Your ref: SSD-47320208 File no: MC-23-00004

SSD-447320208 – Project Echidna Data Centre, Eastern Creek

Blacktown Council's submission to SSD-47320208 – 10 Eastern Creek Drive Project Echidna Data Centre

TITLE: EROSION AND SEDIMENT CONTROL PLAN SHEET 1

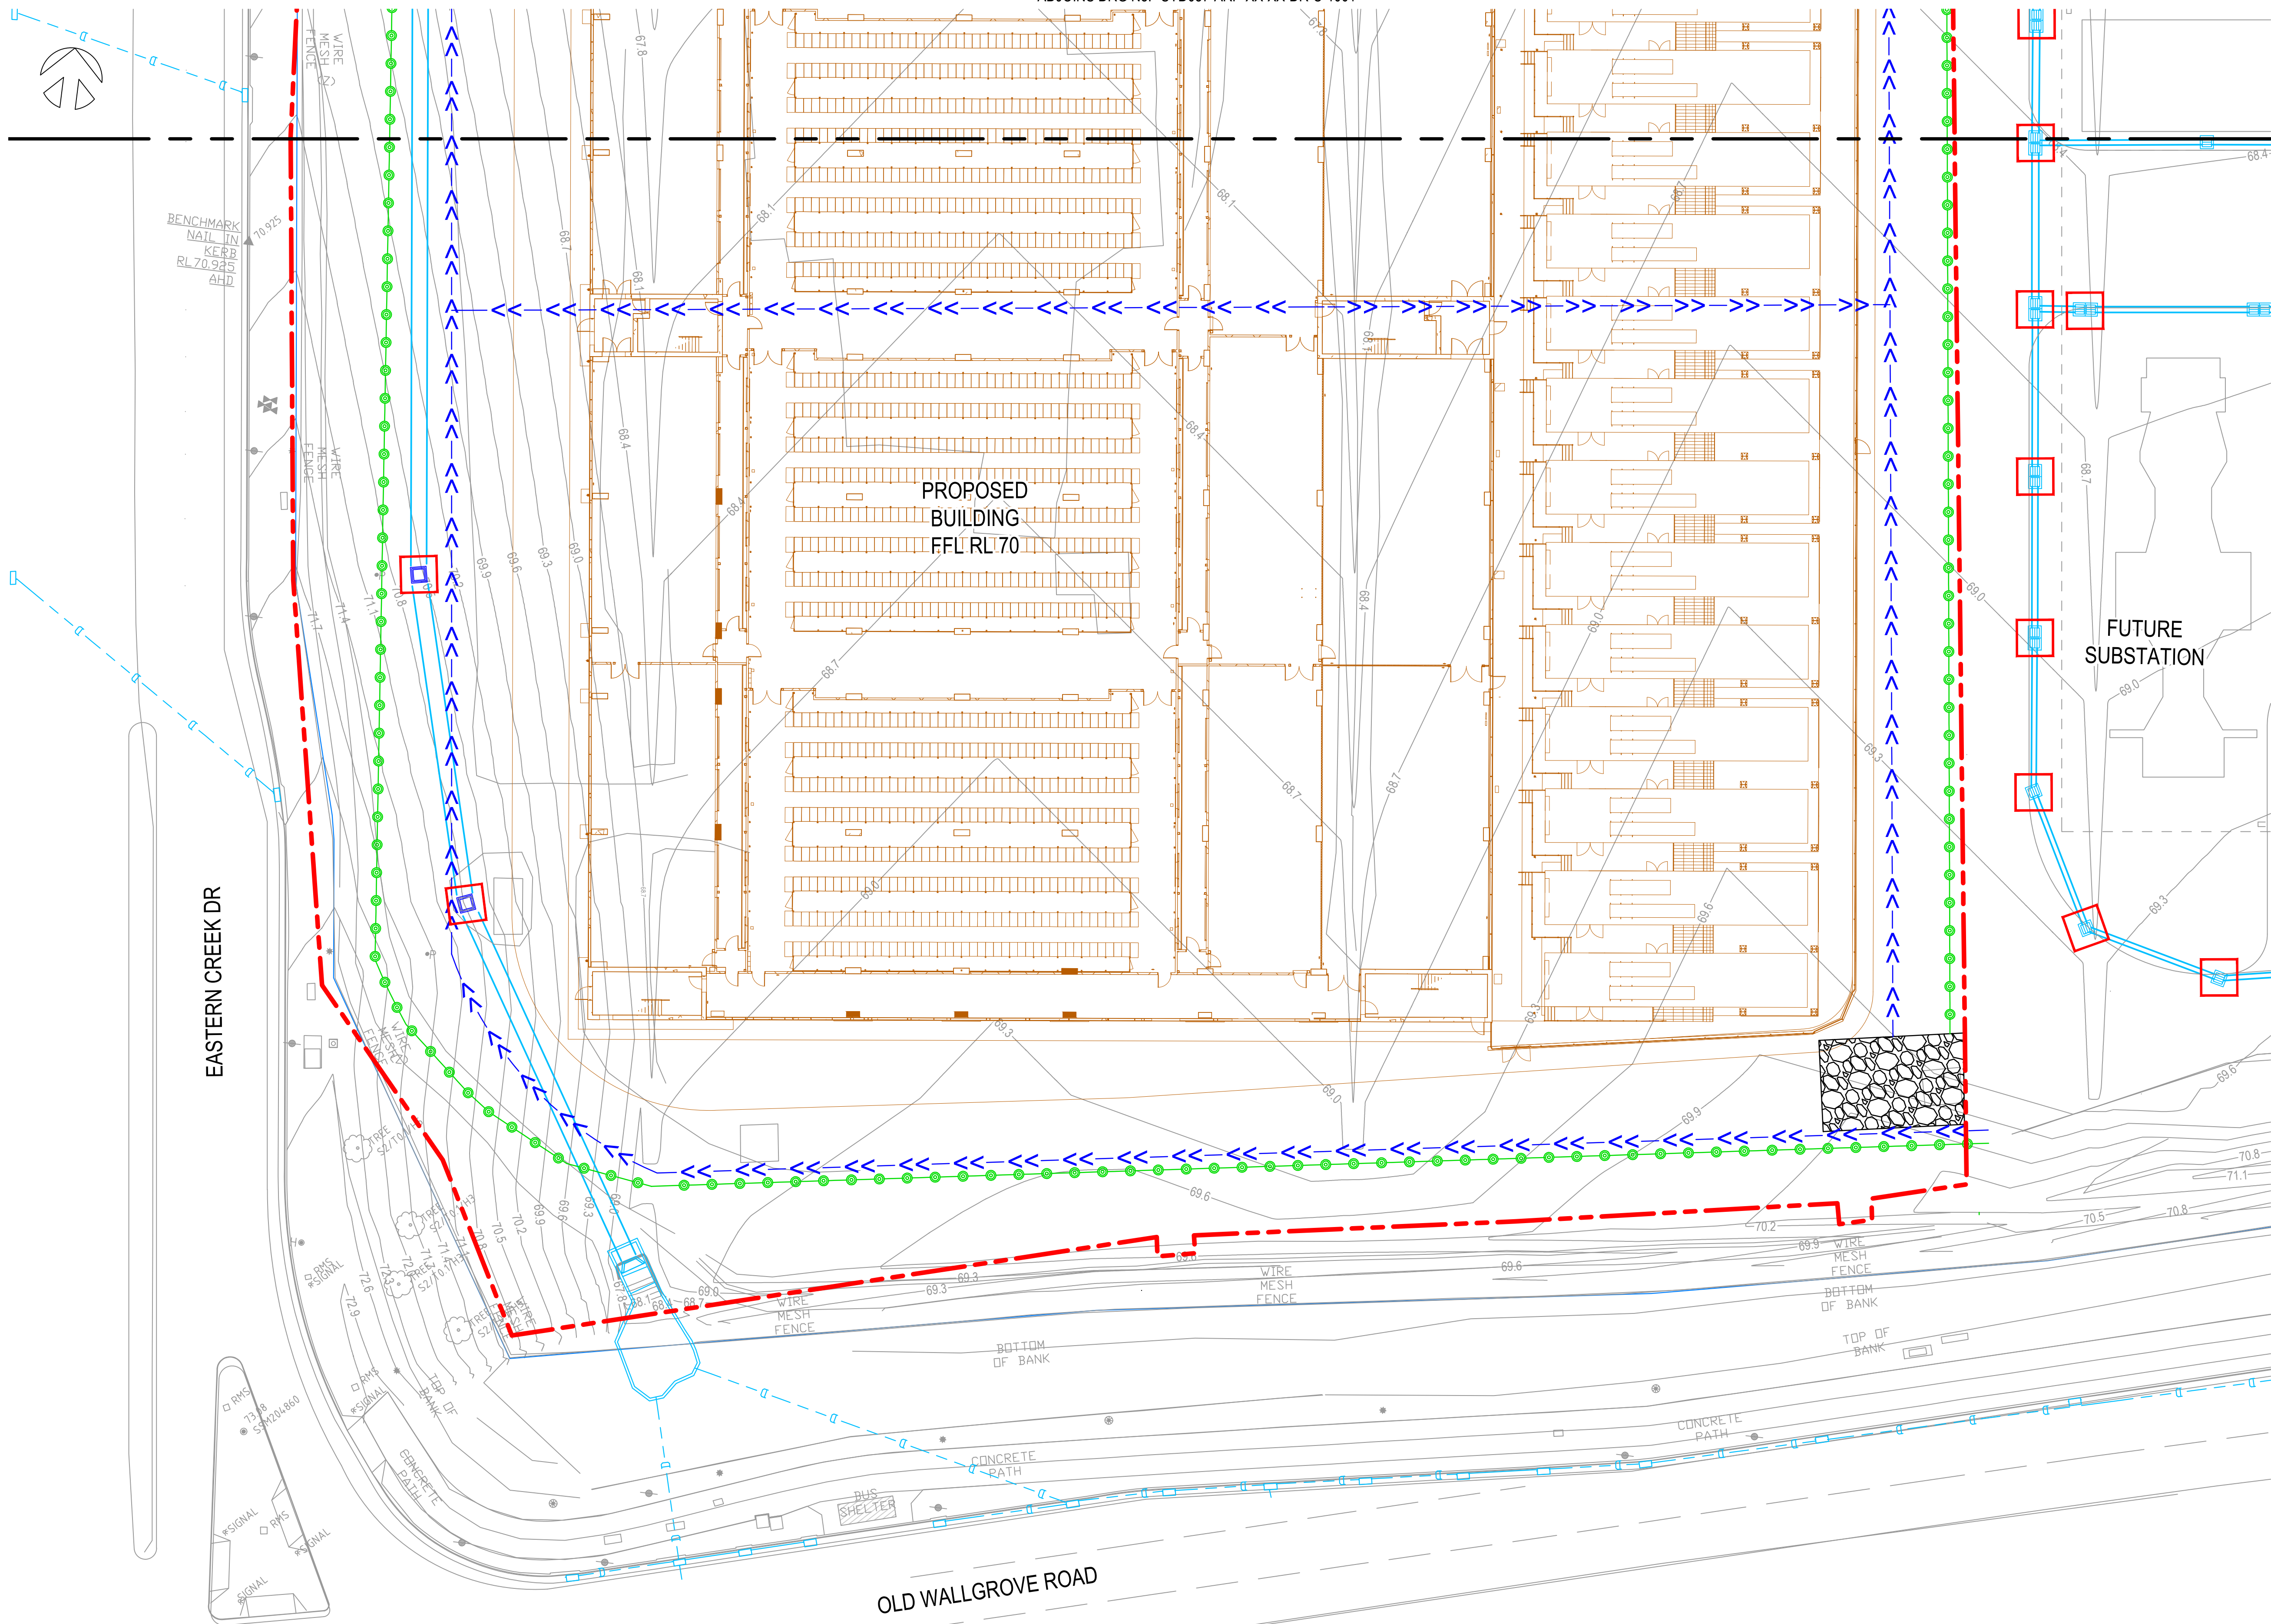
- c. The applicant must provide a Soil and Water Management Plan for implementation prior to the construction of the development, with adequate erosion and sediment control measures implemented.
